RE:

Will & Co

I am writing with reference to the attached submissions (excluding some of the civil plans) that you sent earlier this month to address the conditions of the Planning Board's approval for this this project. My comments IN CAPS and are set in the context of the relevant condition:

1 FLOOR PLAN - GARAGE/BASEMENT
 SCALE: 1/4" = 1'-0"

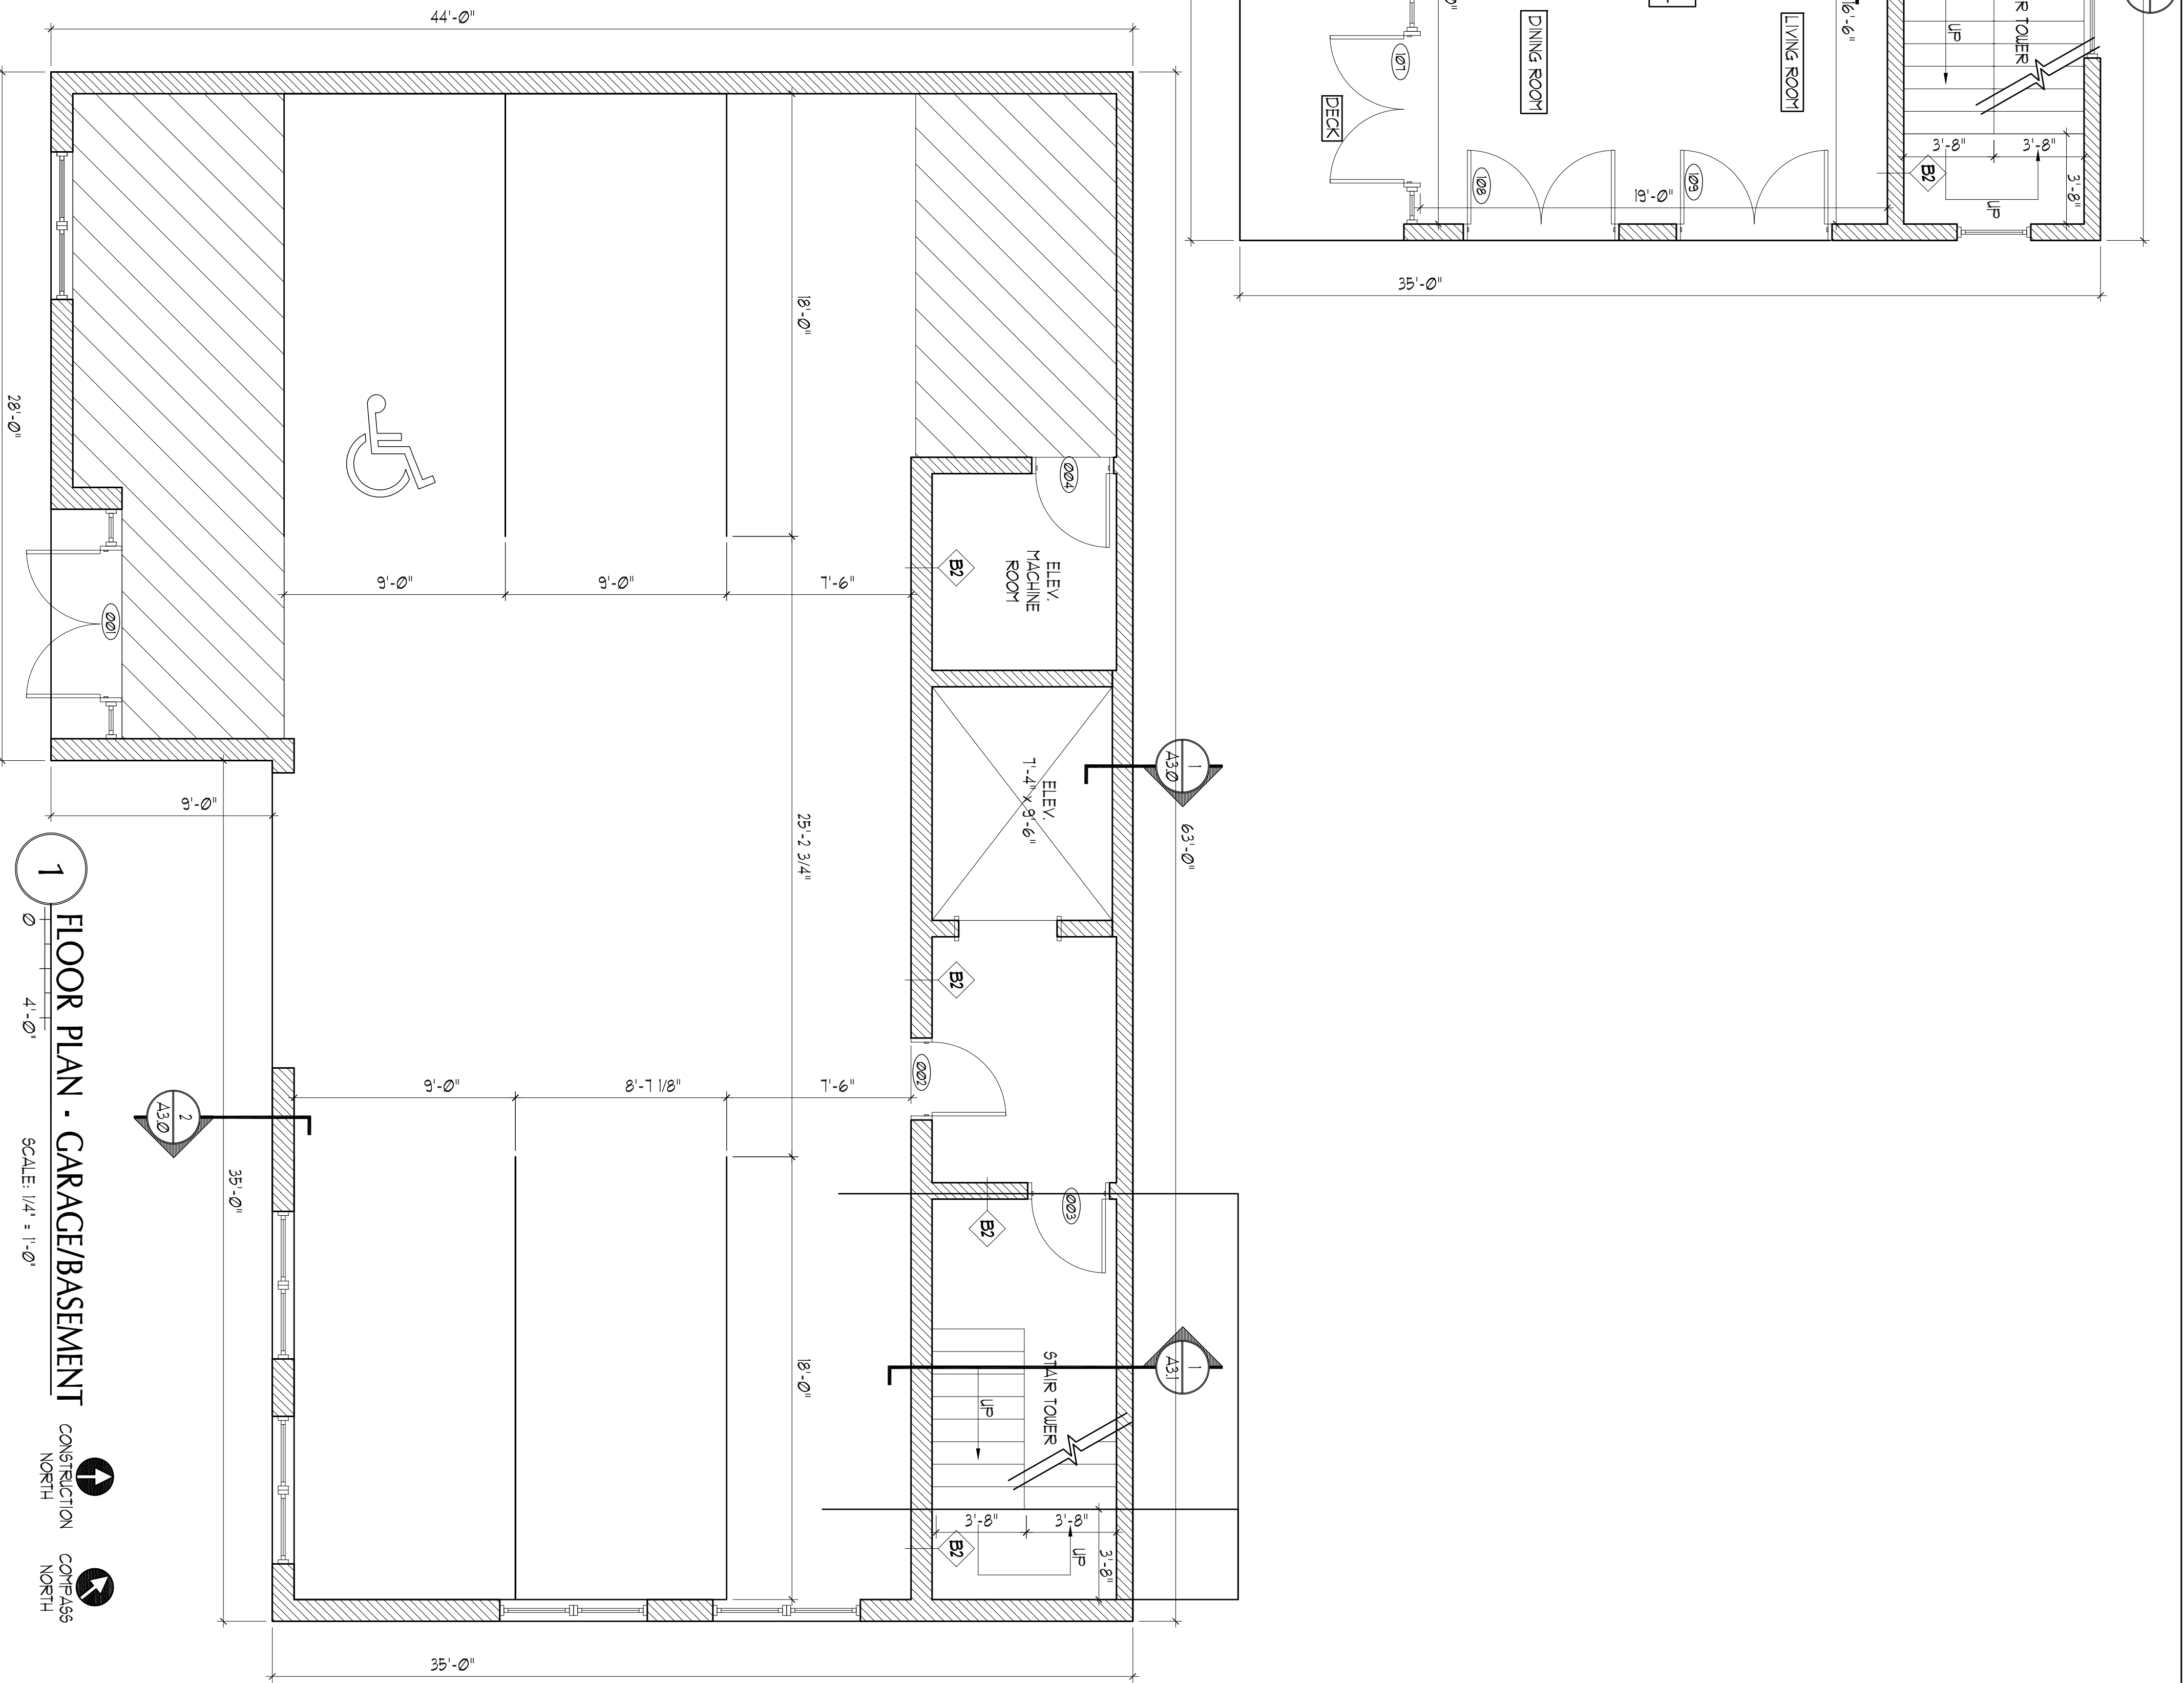
PLEASE SEND THE FINAL SET OF FLOOR PLANS (INCLUDING THE GARAGE LEVEL TO MATCH THE SITE PLAN) WITH AN ARCHITECTS STAMP AND NOTE TO SHOW THAT THE ARCHITECT HAS CONFIRMED THESE MEET ADA REQUIREMENTS. [WE ARE NOT SURE THAT THE PARKING SPACE MEETS ADA BUT IF THE ARCHITECT CONSIDERS IT DOES THEN HIS STAMP WILL COVER THAT re the condition.]

DRAWING NAME: **SITE PLAN**
 PROJECT NAME: **31 FORE STREET REDEVELOPMENT**
 CLIENT: **PENINSULA PROPERTY DEVELOPMENT, LLC.**
 ADDRESS: 59 MOODY STREET, PORTLAND, MAINE 04101

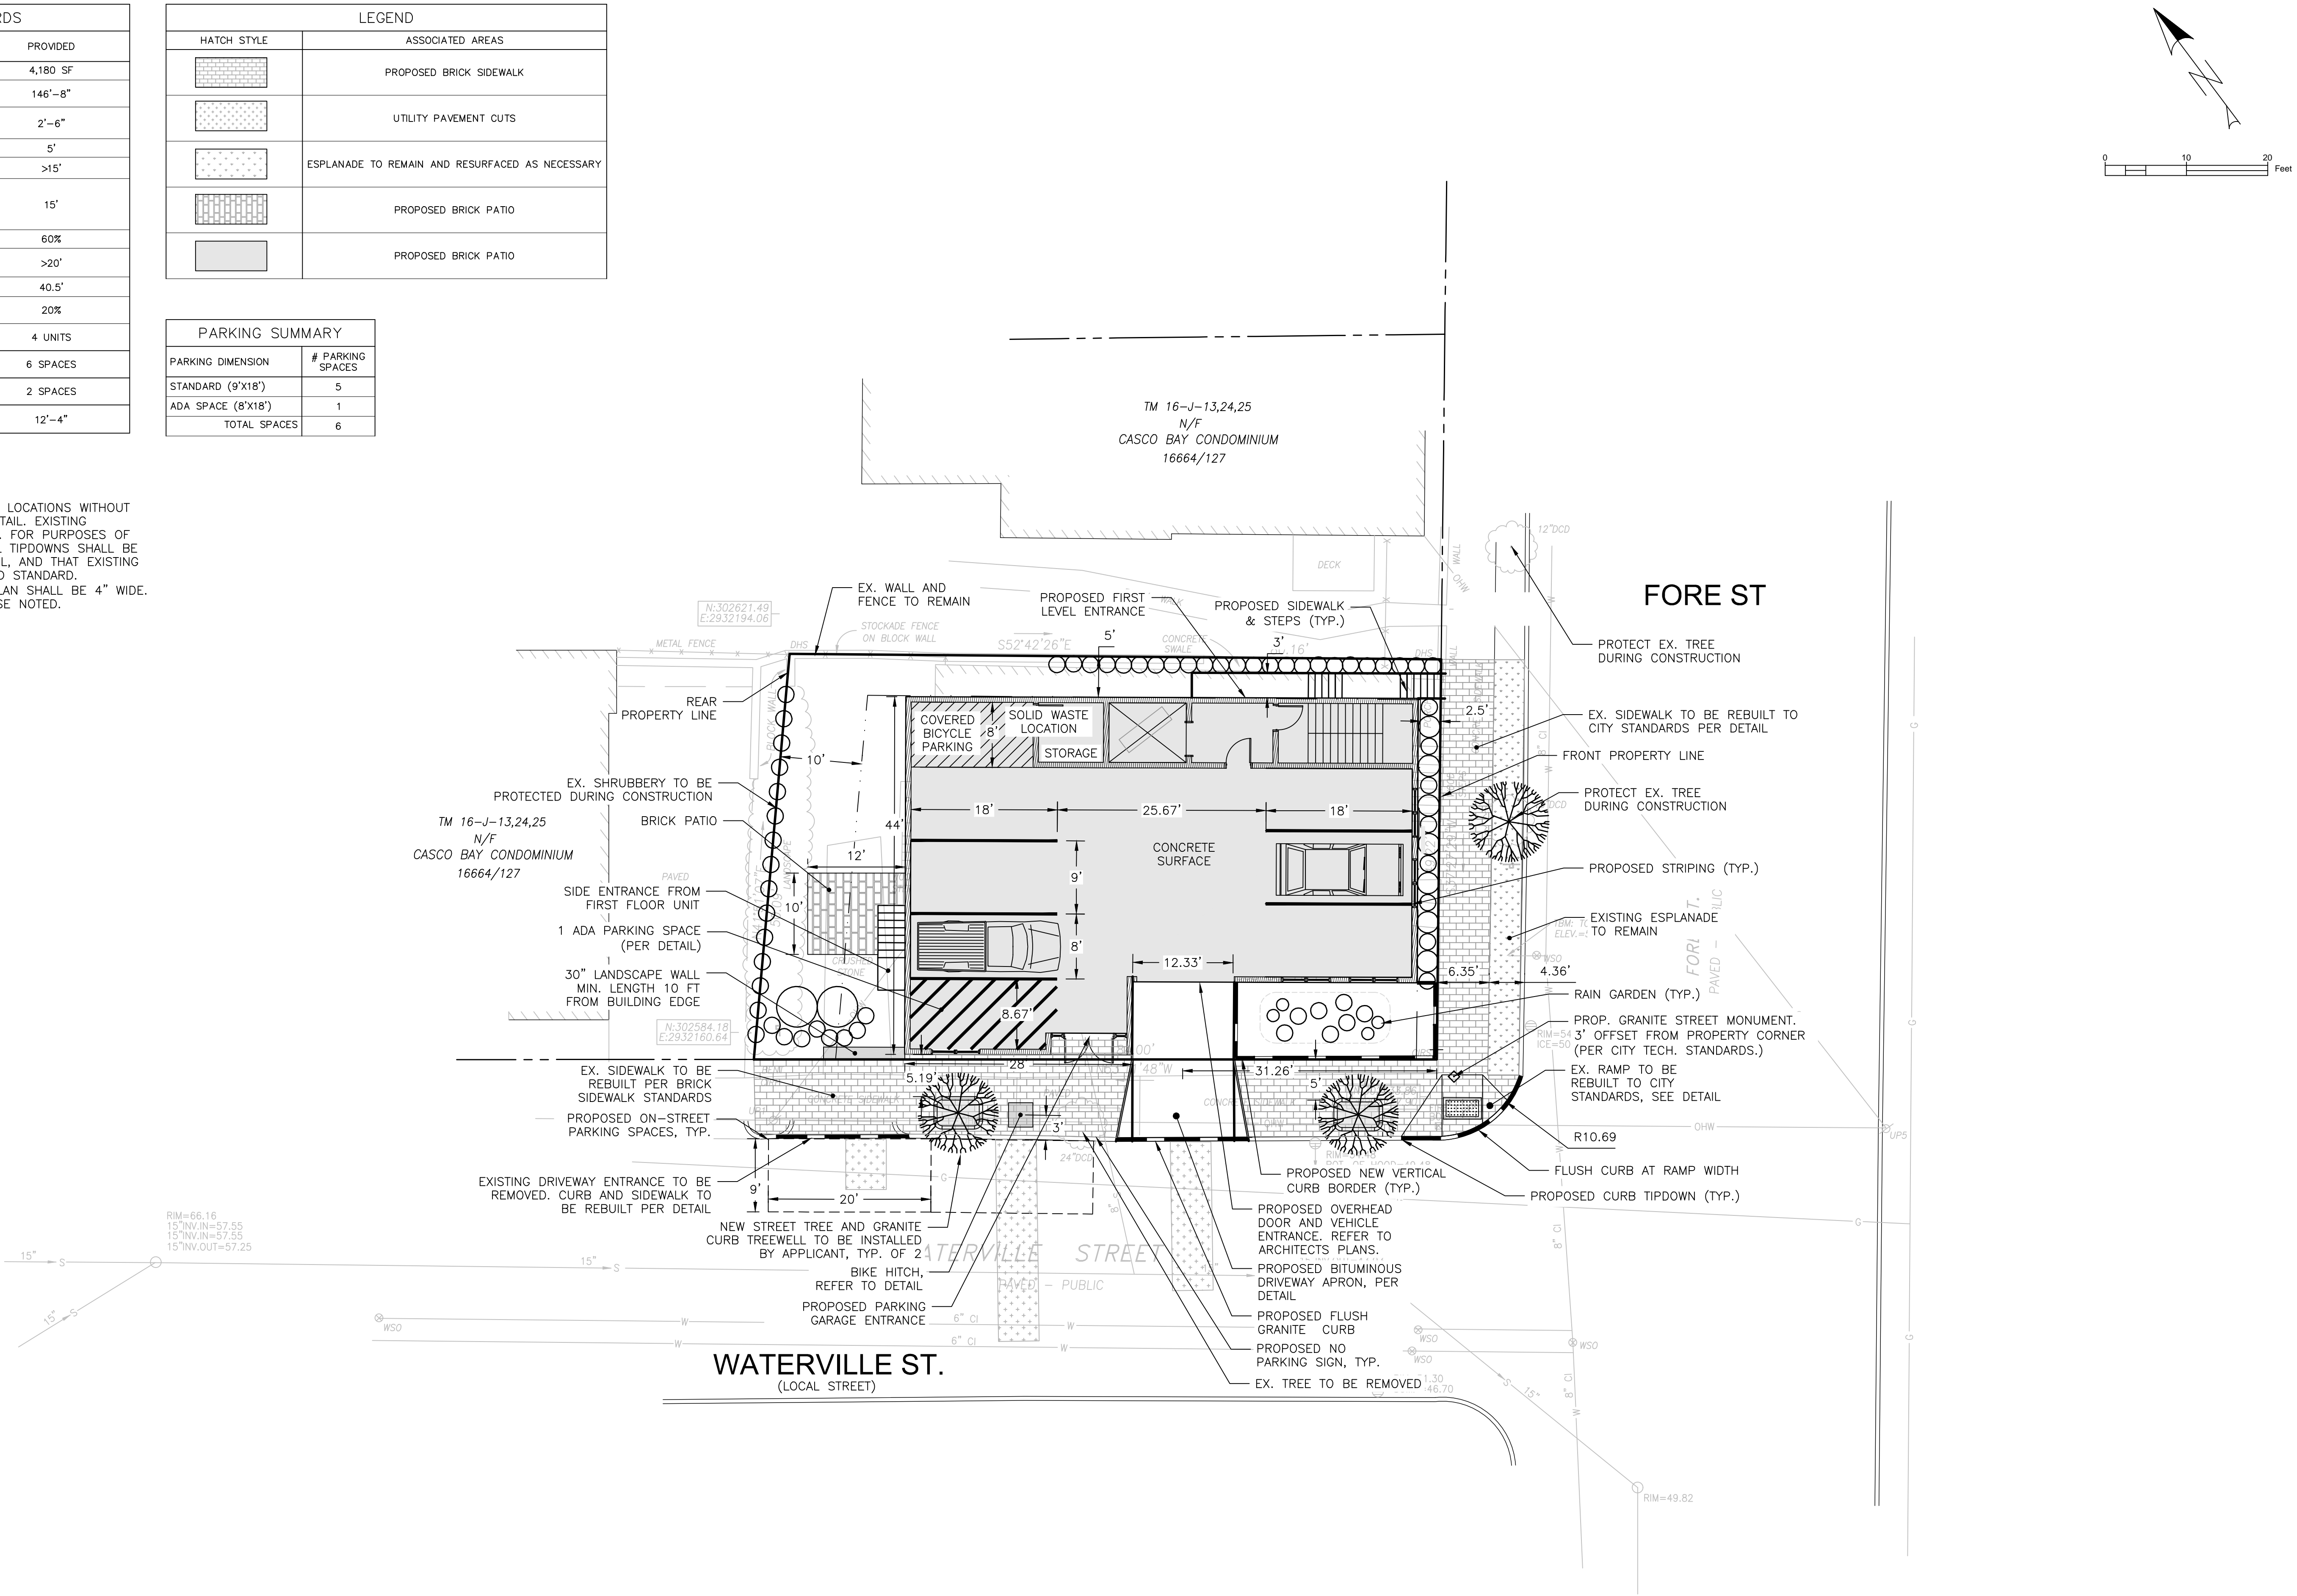
PLEASE ADVISE ME AS TO WHERE THE REQUESTED NOTE (SEE #5 FROM DAVID MARGOLIS-PINEO) HAS BEEN ADDED TO THE PLAN SET; WE NOTE THAT THE BACKFLOW PREVENTER HAS BEEN RELOCATED WITH A CONCRETE COLLAR, BUT STILL APPEARS TO BE IN THE ROW (AND THE NOTE REFERS TO IT BEING IN THE ROW) AND I DO NOT HAVE A DPW SIGN OFF RE THAT..

- With regards to comment i.a. below please refer to the attached revised Utility Plan. The plan clarifies the location of the backflow preventer in note (note 5) and plan form. The final comment from David was within the General Notes #10 of the plan.
- I have updated the CMP to incorporate Tom Errico's comments. Changes are italicized in the attached.
